Subject: Response to Geotechnical Review Comments, Proposed New Residence, 3626 – 90th Avenue SE, Mercer Island, Washington.

Reference: Geotechnical Engineering Investigation, Proposed New Residence, 3626 – 90th Avenue SE, Mercer Island, Washington. GEO Group Northwest, Inc., April 18, 2023.

GEO Group Northwest, Inc. has prepared this response letter to the geotechnical review comments dated May 9, 2023, regarding the proposed construction of a new residence at the subject location in Mercer Island, Washington. The comments and our responses are provided below.

FIGURE :SLOPE STABILITY ANALYSIS

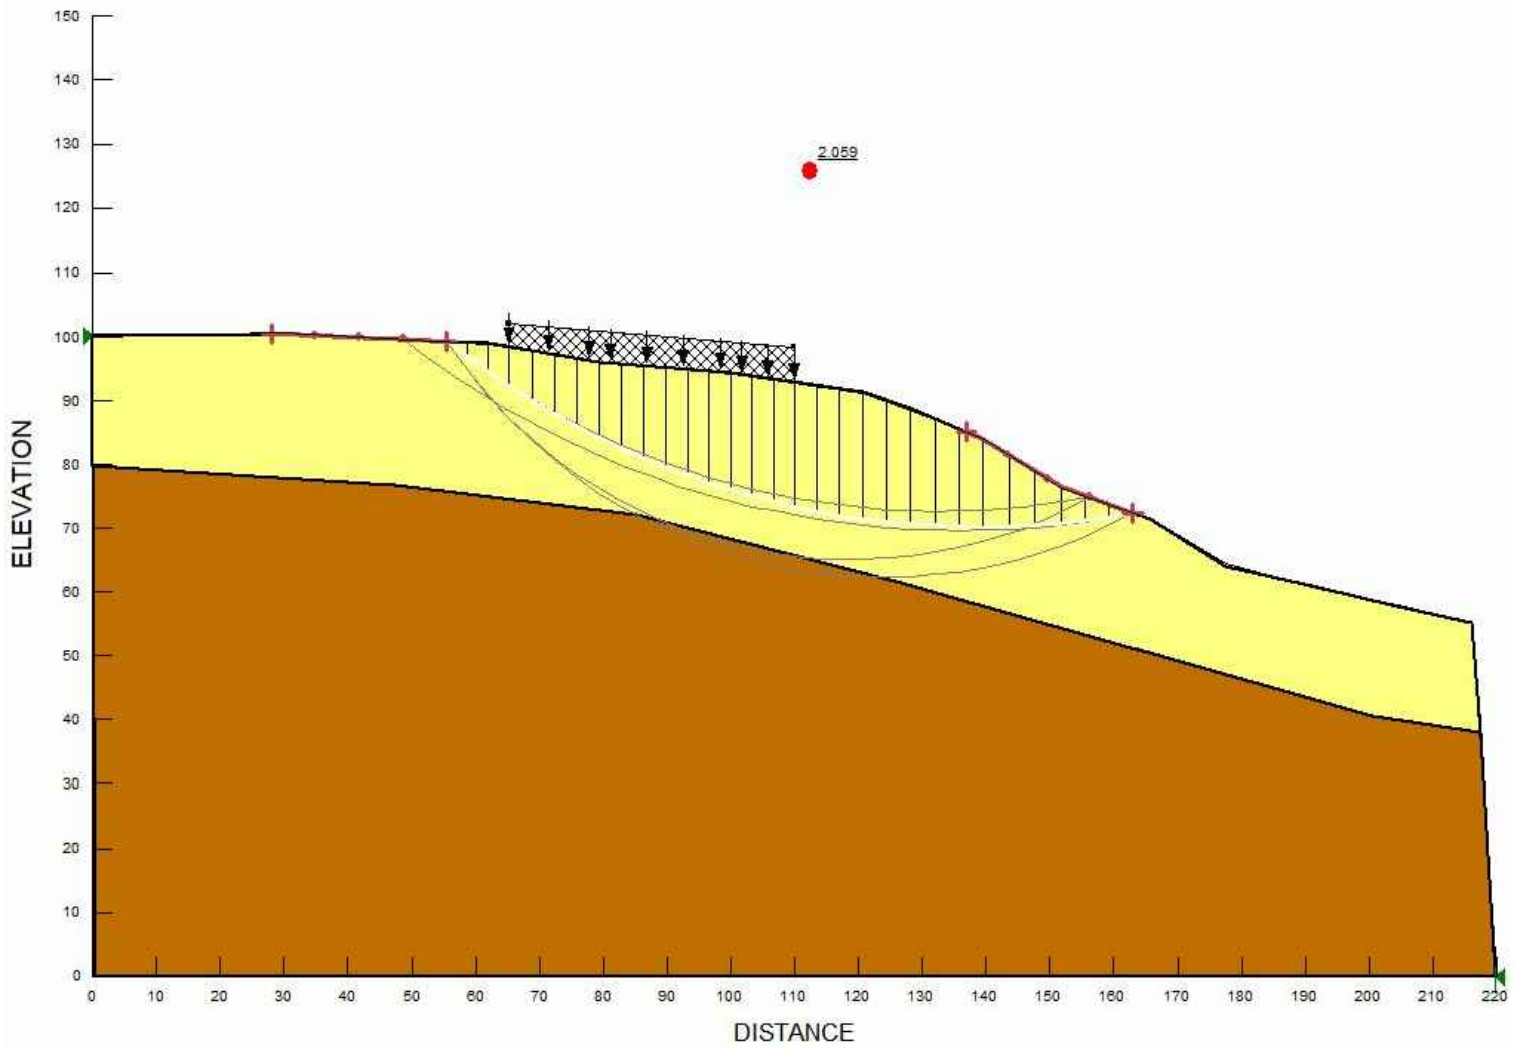
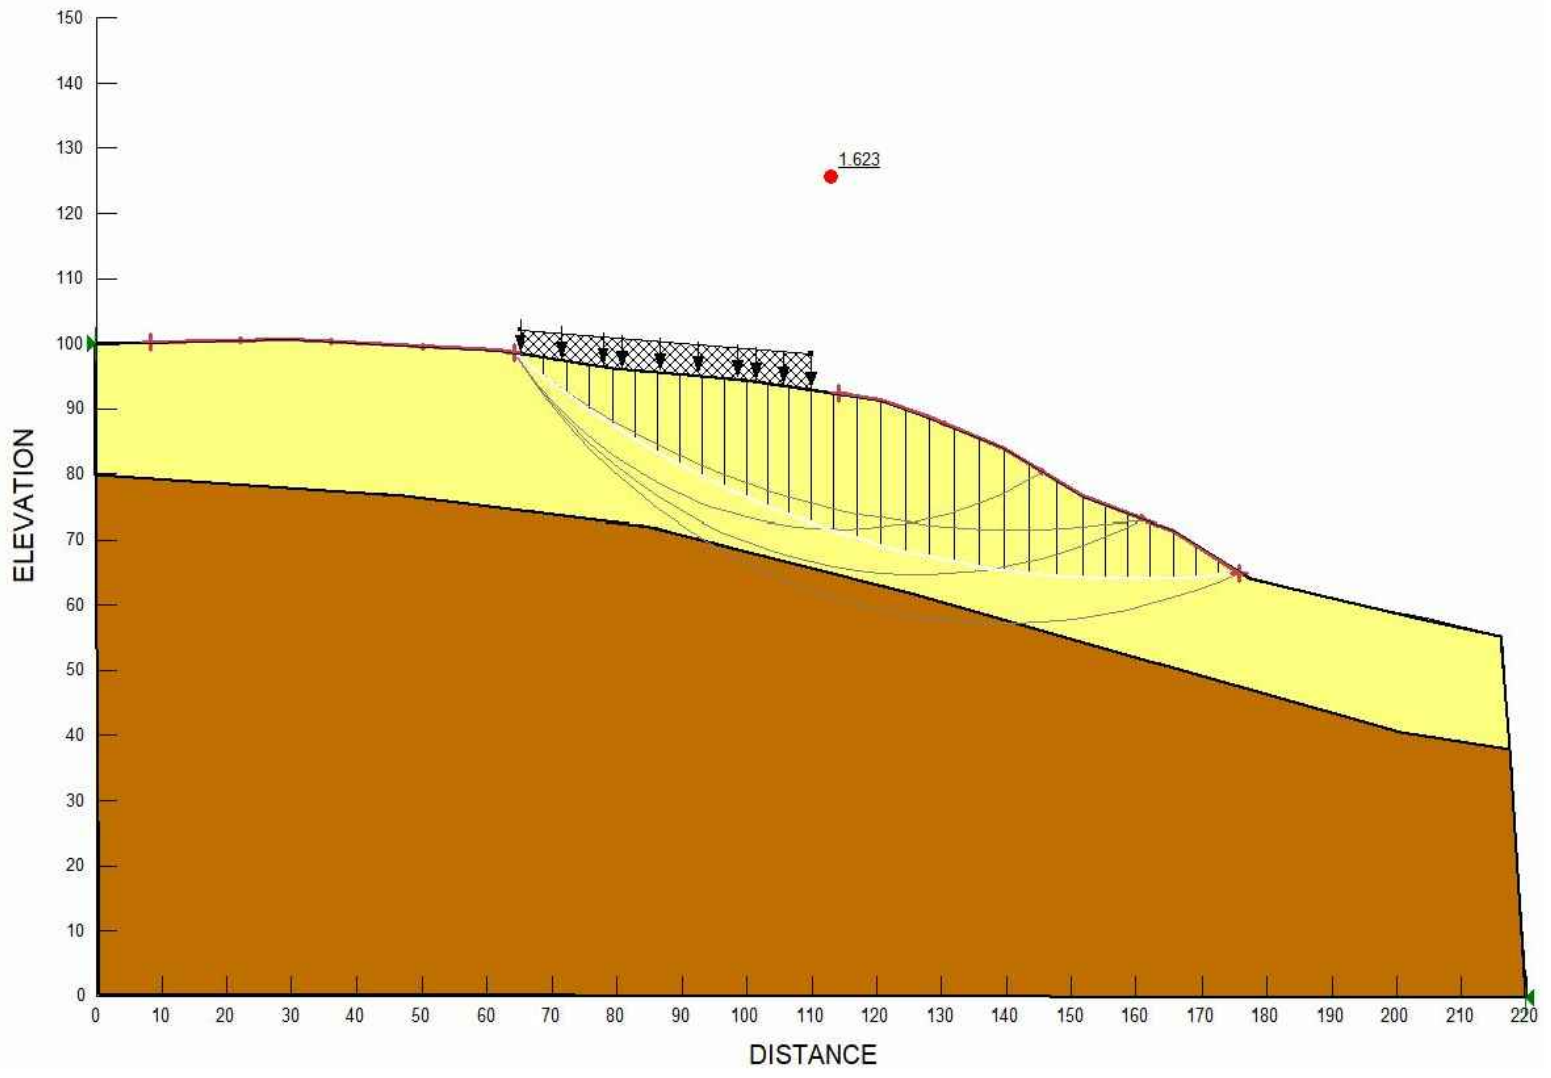
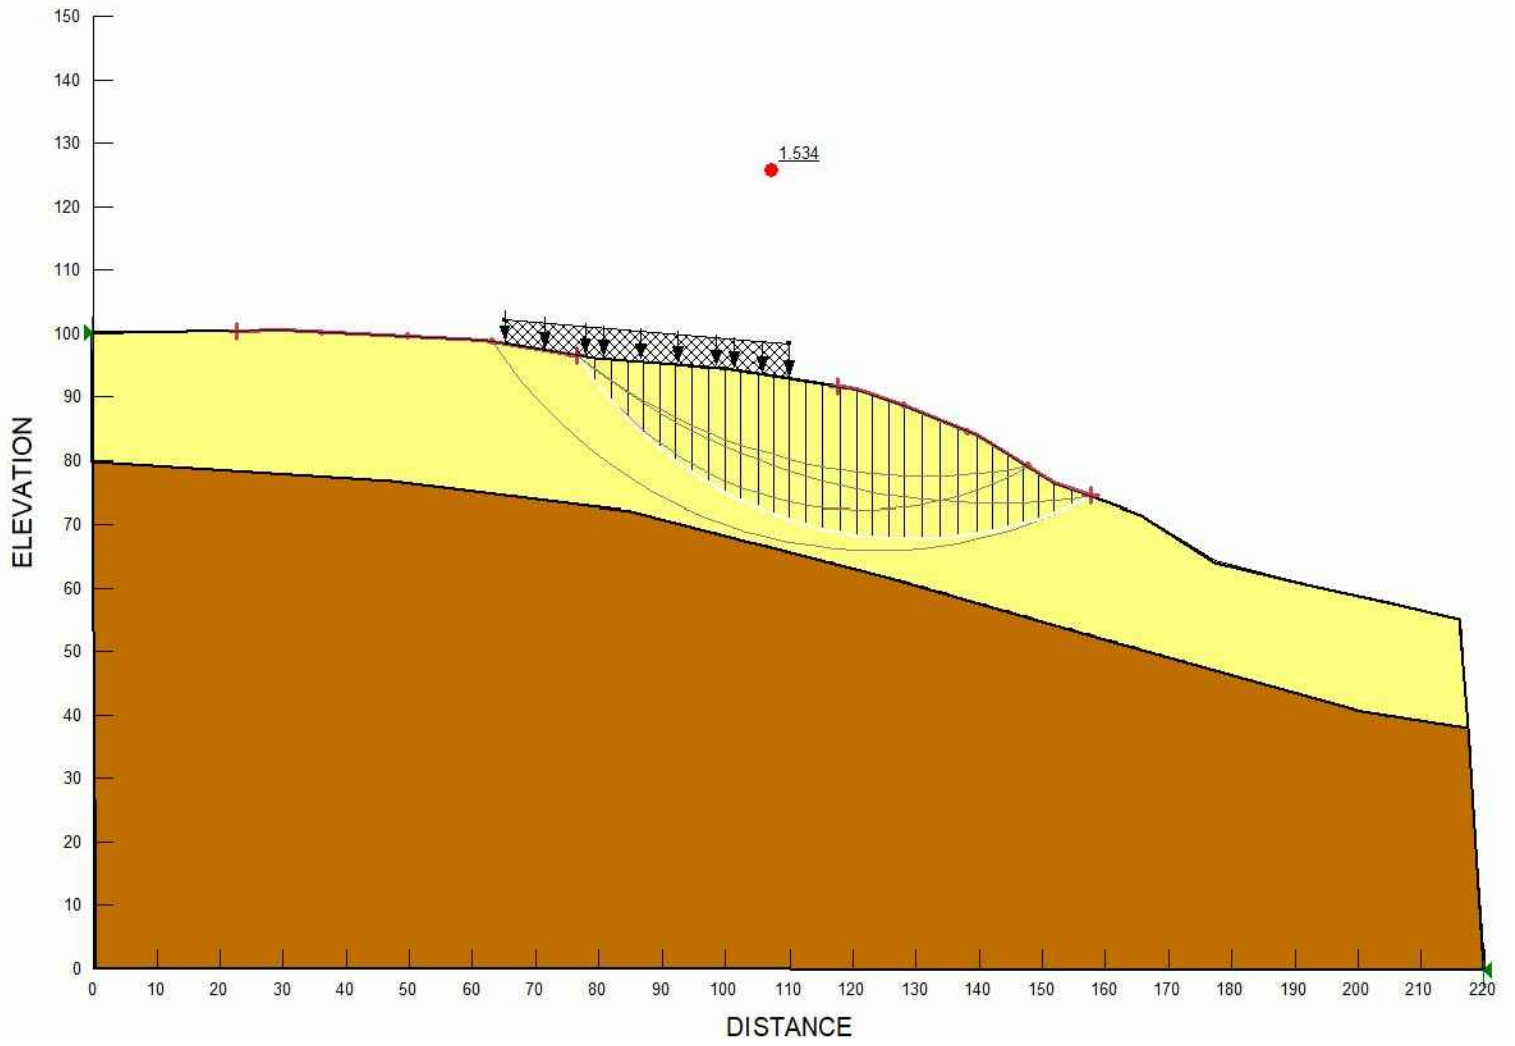
Please include discussion of how the seismic coefficient (0.22) was determined. Please include calculations for review and cite references used to determine the seismic coefficient.

If the use of the seismic coefficient of 0.22 cannot be supported by calculation or technical references citing alternate methodologies please revise seismic stability analyses. Discuss impacts of seismic slope instability, e.g., estimated slope deformations and associated structural impacts. Please provide mitigation recommendations, if

applicable. Please present revised stability analysis results and subsequent recommendations in a report addendum.

Following receipt of the review comments, we have reviewed technical literature regarding alternative procedures for the estimation of the pseudo-static coefficient value for the analysis of seismic ground motion on slope stability. We used the procedures described in Bray and Travararou (2011)¹ to evaluate the relationship between seismic displacement and pseudo-static coefficient for use in our analysis.

The value for the pseudo-static coefficient value is calculated to be 0.380 for the specified conditions. When multiplied by the PGA_M value of 0.66g for the site, the pseudo-static loading to be used for the stability analysis is calculated to be 0.251.

Based on findings from the above-described analysis, we updated our slope stability analysis for the project site using the value of 0.251g, for the pseudo-static loading. The results from the updated analysis are presented in Attachment B to this letter.

The results indicate that the extents of the potential slope displacement surfaces do not intersect the proposed residence location. The minimum distance between the building foundations and the surfaces is approximately 8 feet; the outermost foundation element shown in the results profile is an exterior deck column footing that is separate from the building.
